Project name	Salt Box		
Design note title	Response to Arun Engineers Comments 16th November 2021		
Document reference	SAL-HYD-TN-C-GLOS-0005		
Author	Gareth Jones		
Revision	P01		
Date	22 November 2021	Approved	☐

The purpose of this Technical note is to respond to Arun Engineers comments on the 16th November 2021, relating to Condition 12 and 16 of Planning Conditions BE/160/21/DPC for Land at Salt Box West of Shripney Road Bognor Regis: -

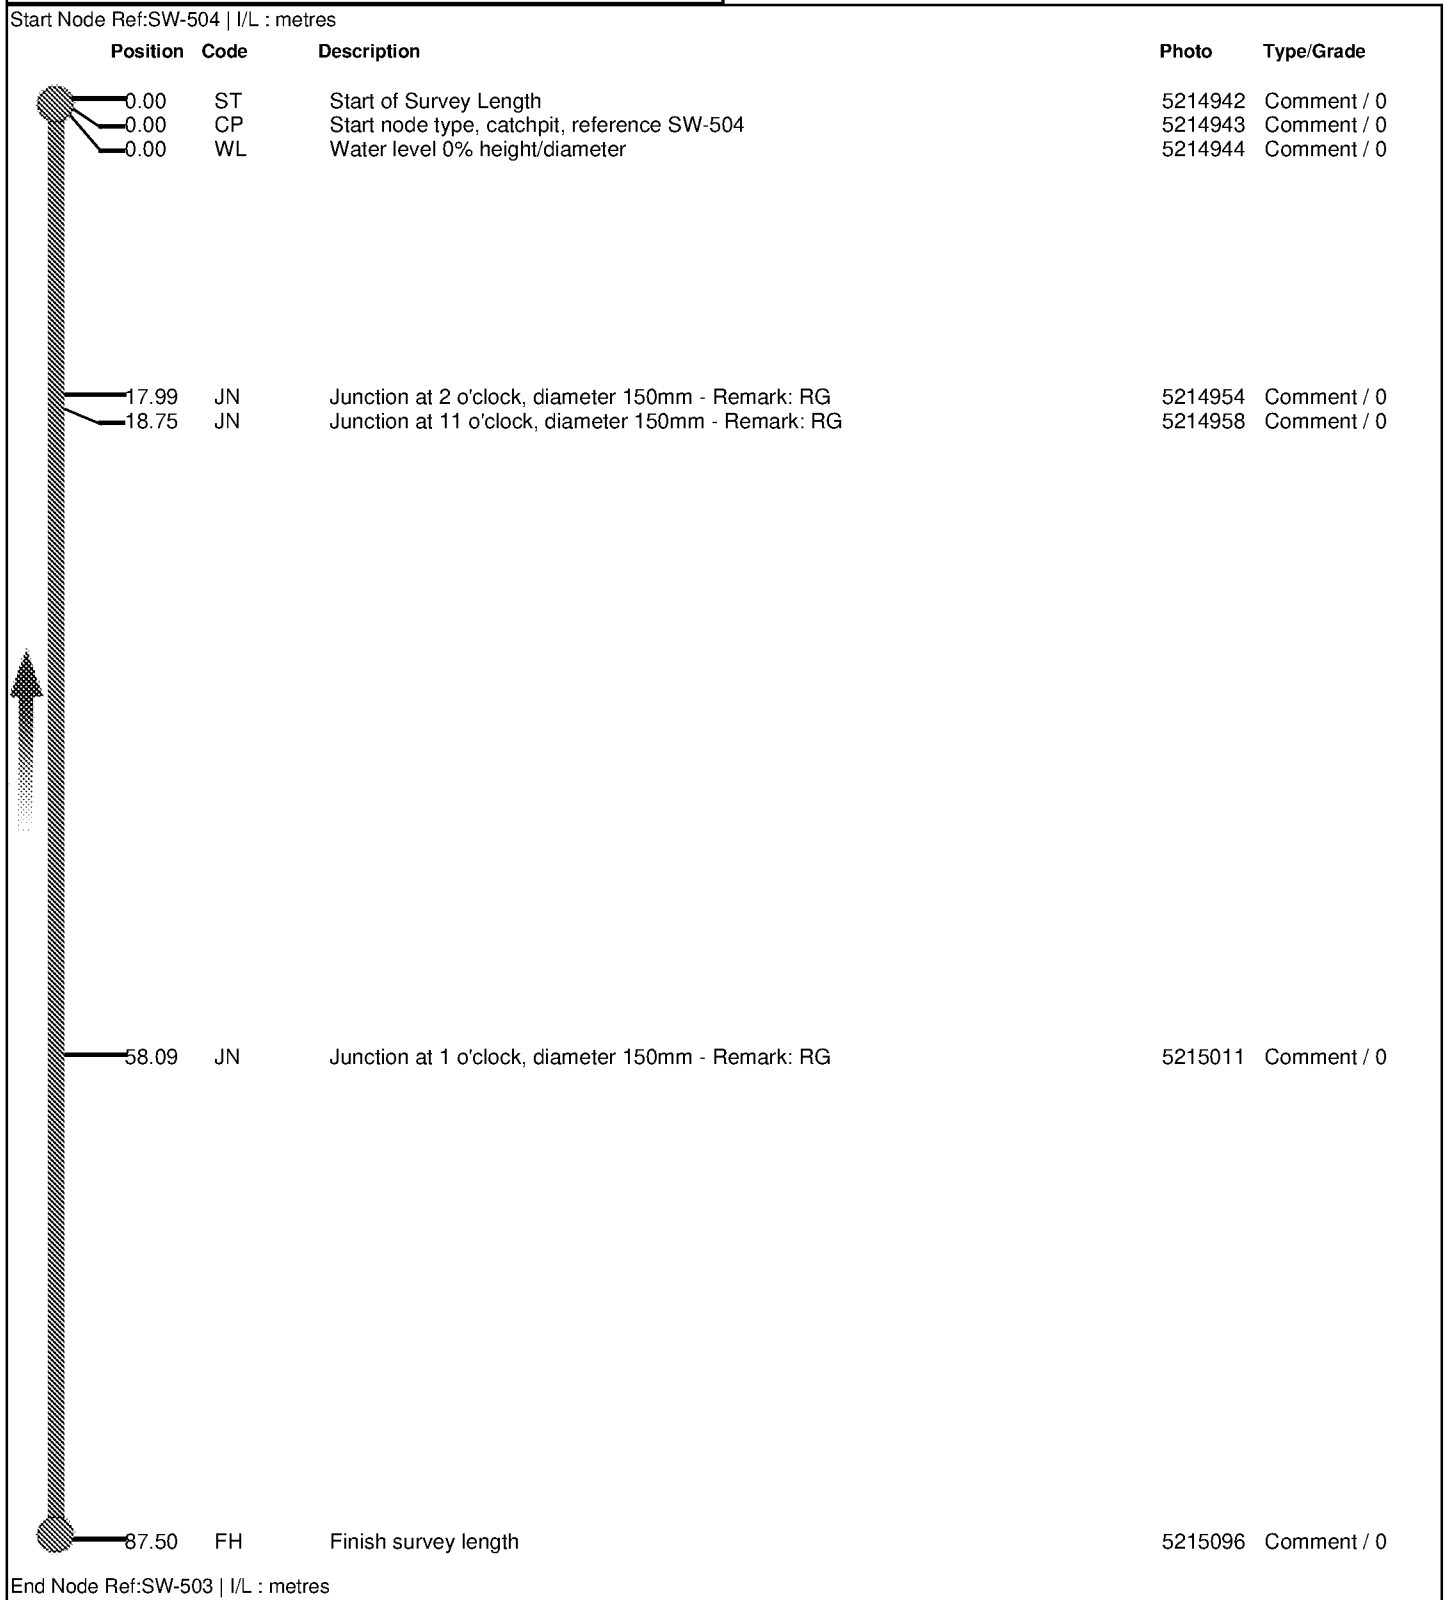
"Engineers Comments Regarding Condition 12 - Several pipes have been constructed very slack. For example the pipe downstream of SW-503 is a 450 diameter pipe, and has been constructed at 1:636. This is not suitable. All pipes should achieve 1m/s velocity.

Although a very small number of the pipes have been installed at a shallower gradient than designed, such minor discrepancies are not unusual when dealing with larger schemes such as this. I have assessed these during the course of my independent review and do not regard this change as material. Their falls still allow a fully functional storm water system, operating for 1 in 100-year storm events and future climate change, without causing flooding on or off site. The as-built falls have been inputting into the calculations and models and show that the system works. While steeper gradients would certainly result in more efficient self-cleansing velocities, larger storm events will still achieve > 1 m/s velocity, and annual cyclic maintenance will ensure pipes are in good working order without blockages forming. The additions of catchpit chambers, sumps in gullies and linear channels and permeable paving, will reduce the amount of debris forming in the piped system. I do not envisage any issues with this and risk of flooding due this arrangement is extremely small. The system built and design checks remain in my professional view materially in accord with the originally agreed drainage design.
